**WELWYN HATFIELD BOROUGH COUNCIL
EXECUTIVE DIRECTOR - PLANNING, PUBLIC PROTECTION AND GOVERNANCE**

DELEGATED APPLICATION

Application No: 6/2019/2643/HOUSE
Location: 12 Firs Wood Close Northaw Potters Bar EN6 4BY
Proposal: Installation of side and rear dormers to facilitate a loft conversion
Officer: Mr Tom Gabriel

DESCRIPTION: PROPOSED PLANS & ELEVATIONS

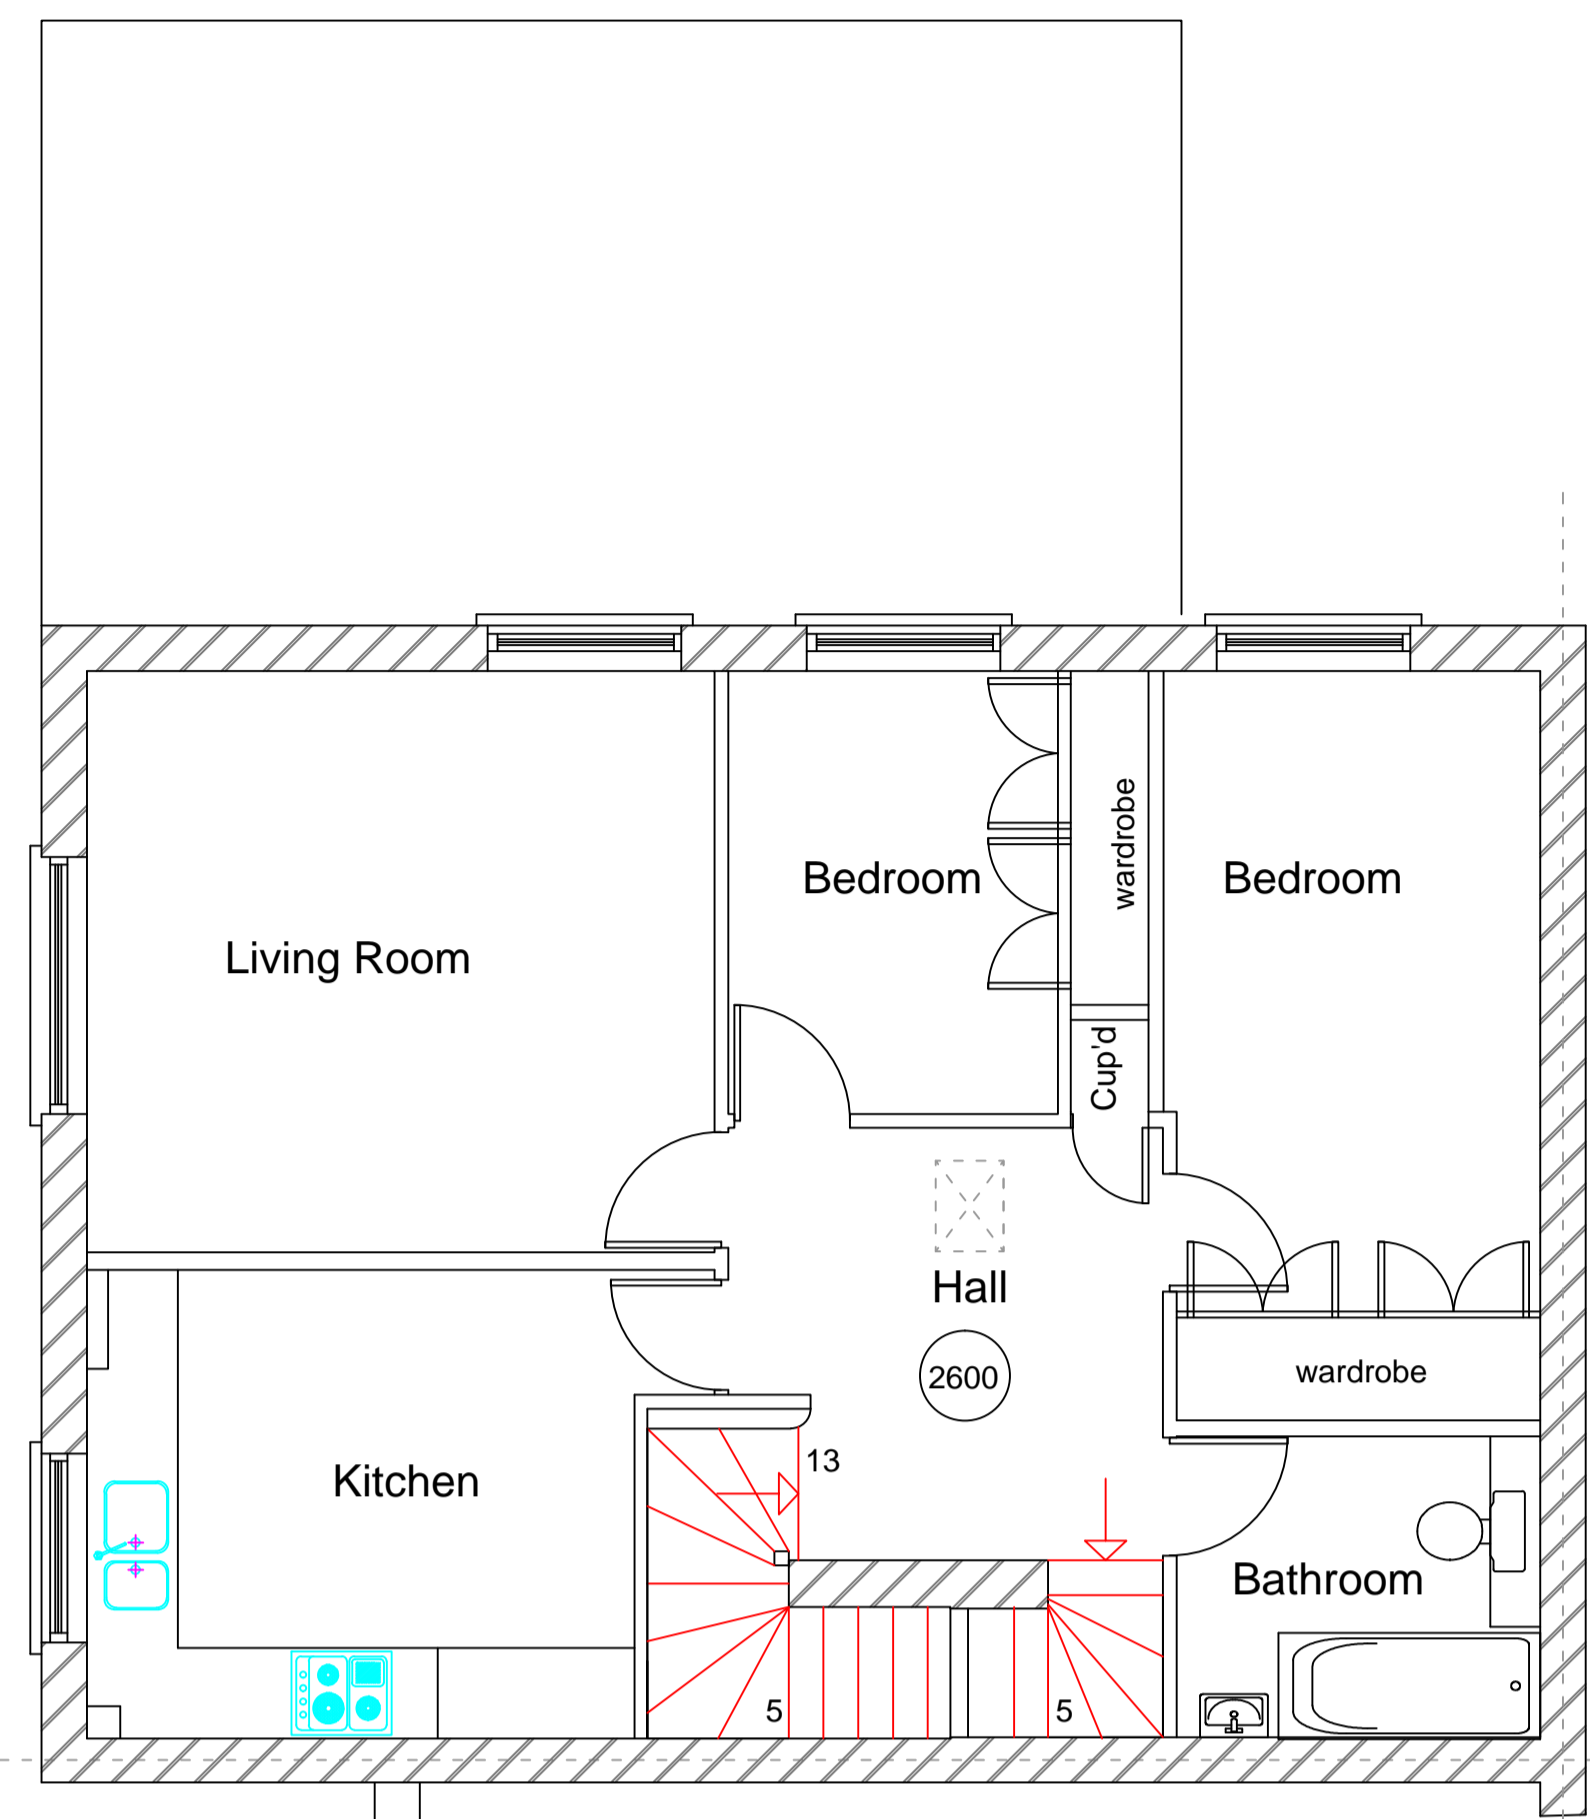
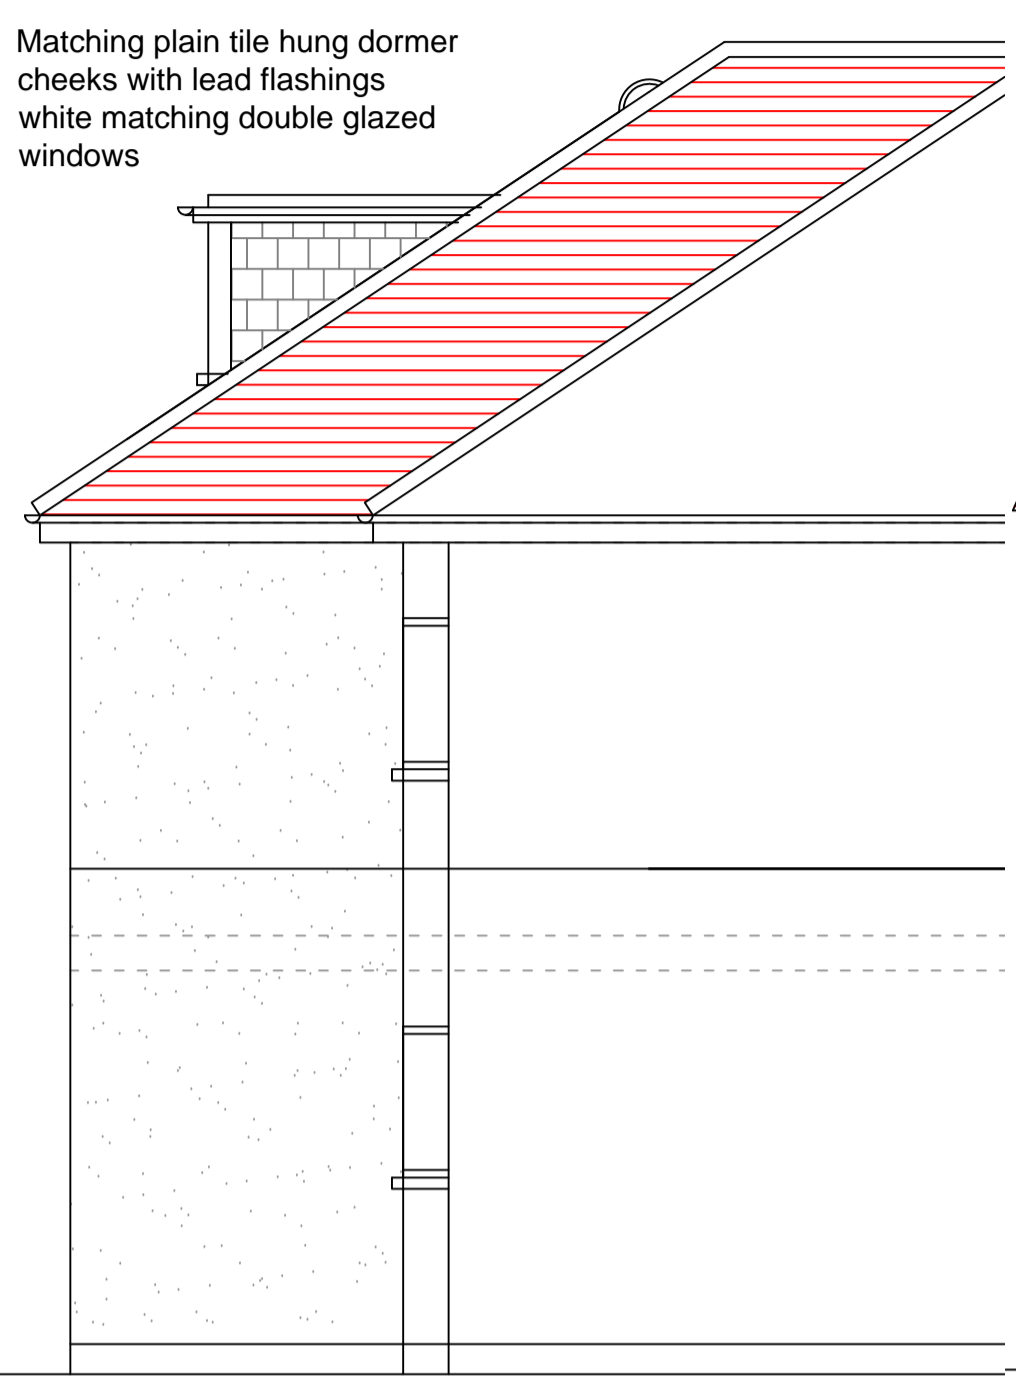
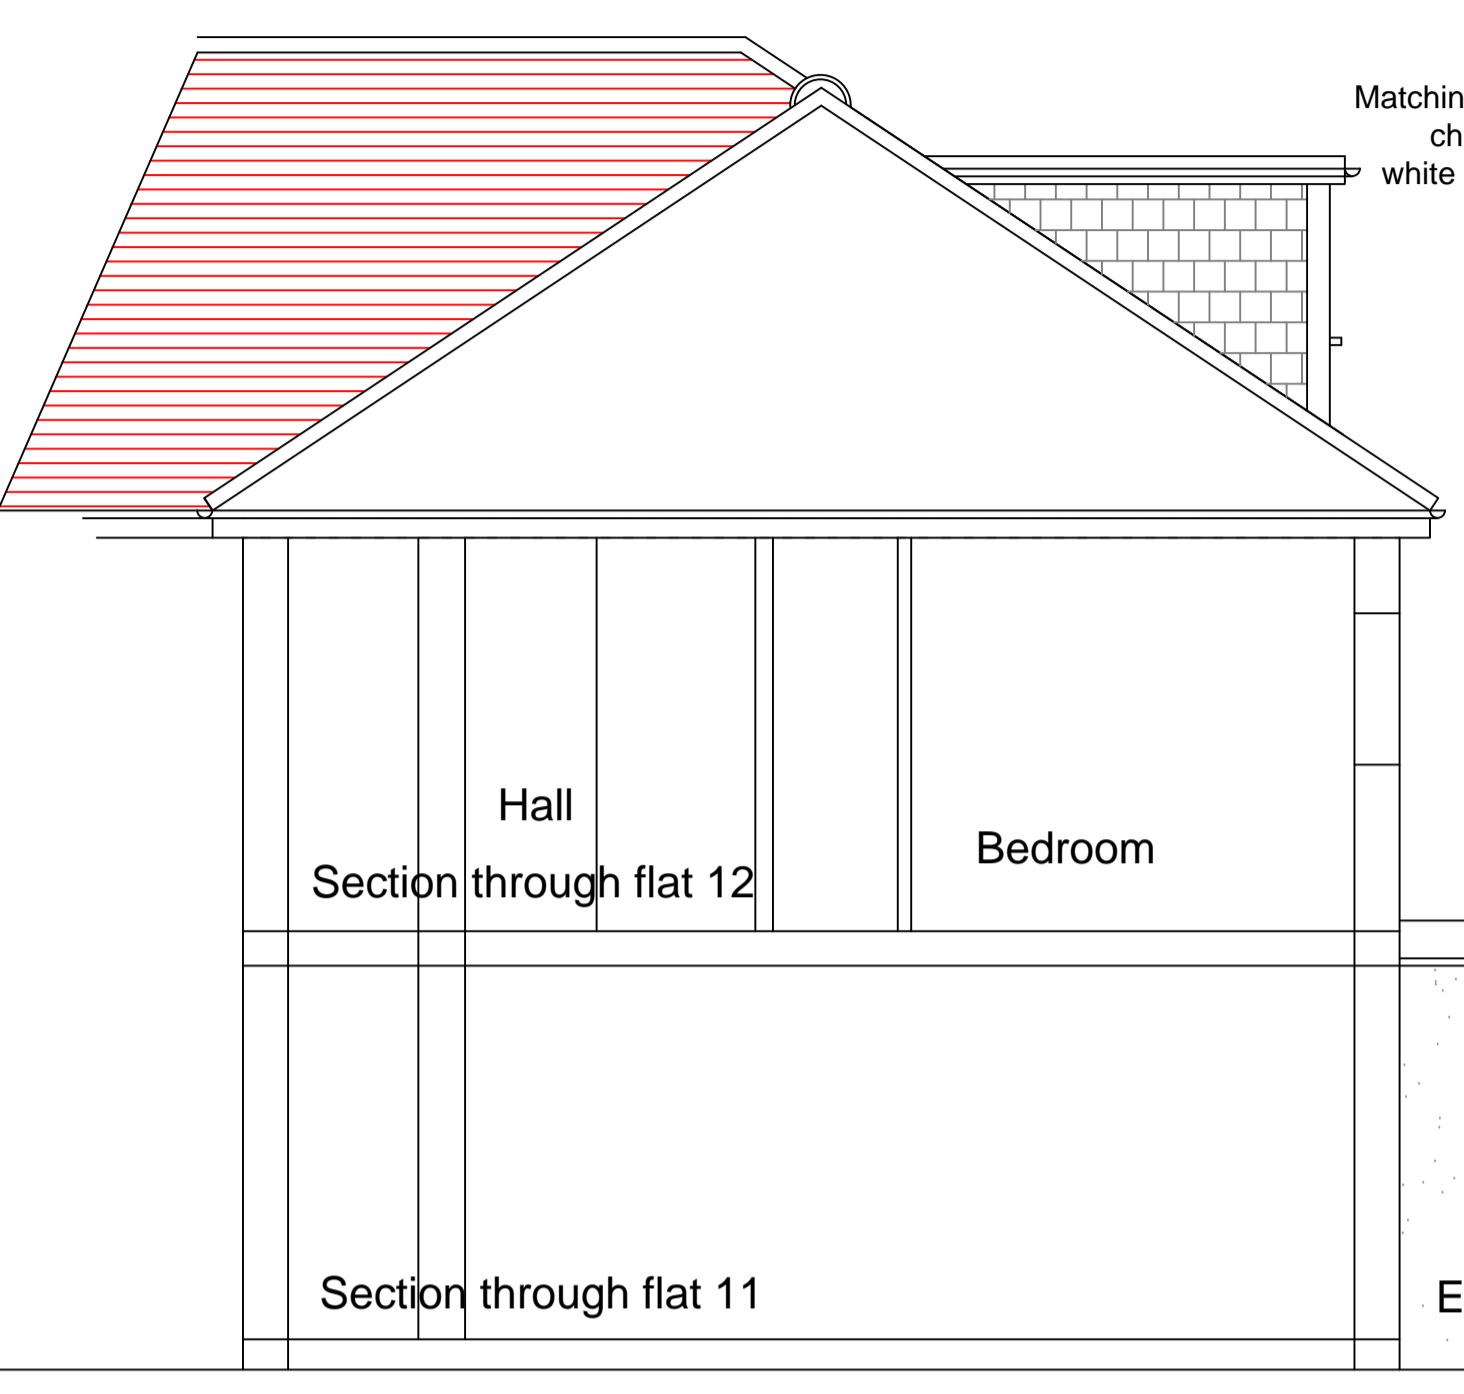
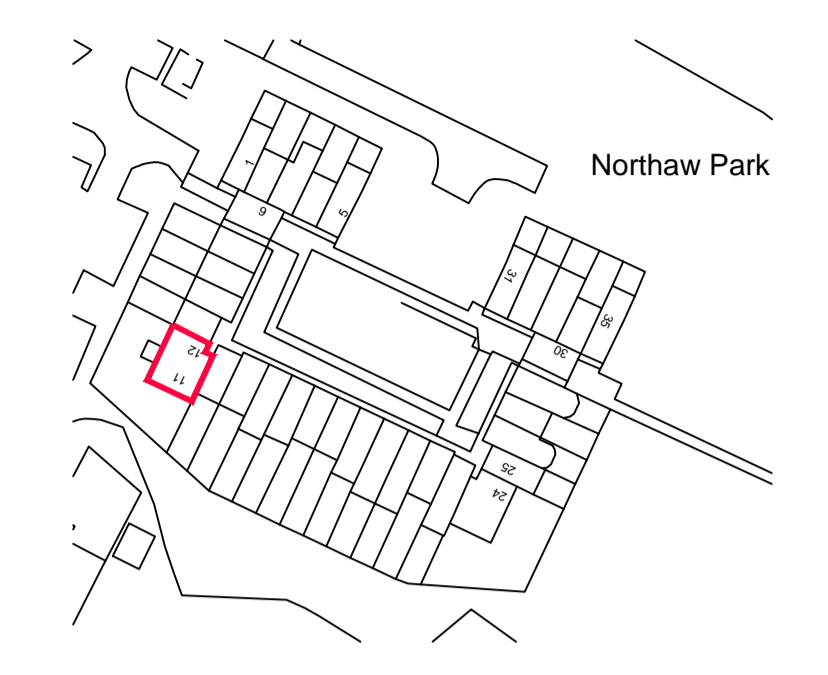
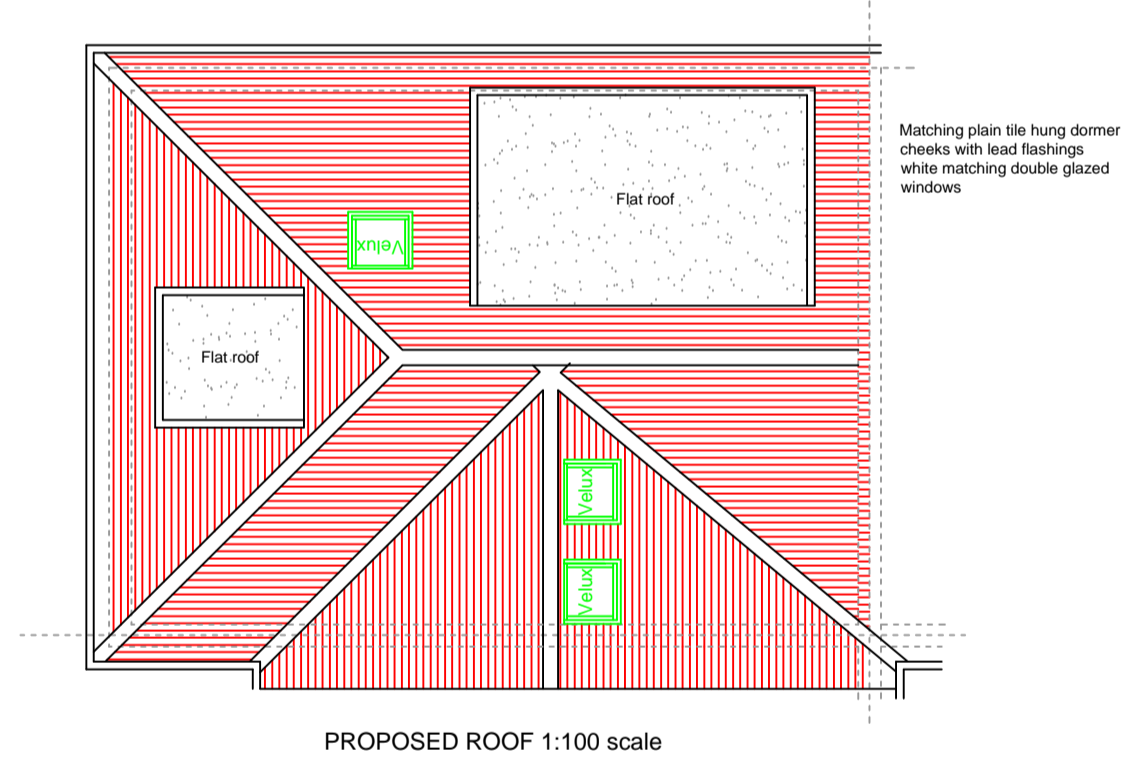
1. Notwithstanding the annotation on the submitted drawings, the hung tiles, windows, guttering, soffits and other external decorations of the approved dormers must match the existing dwelling in relation to colour and texture.
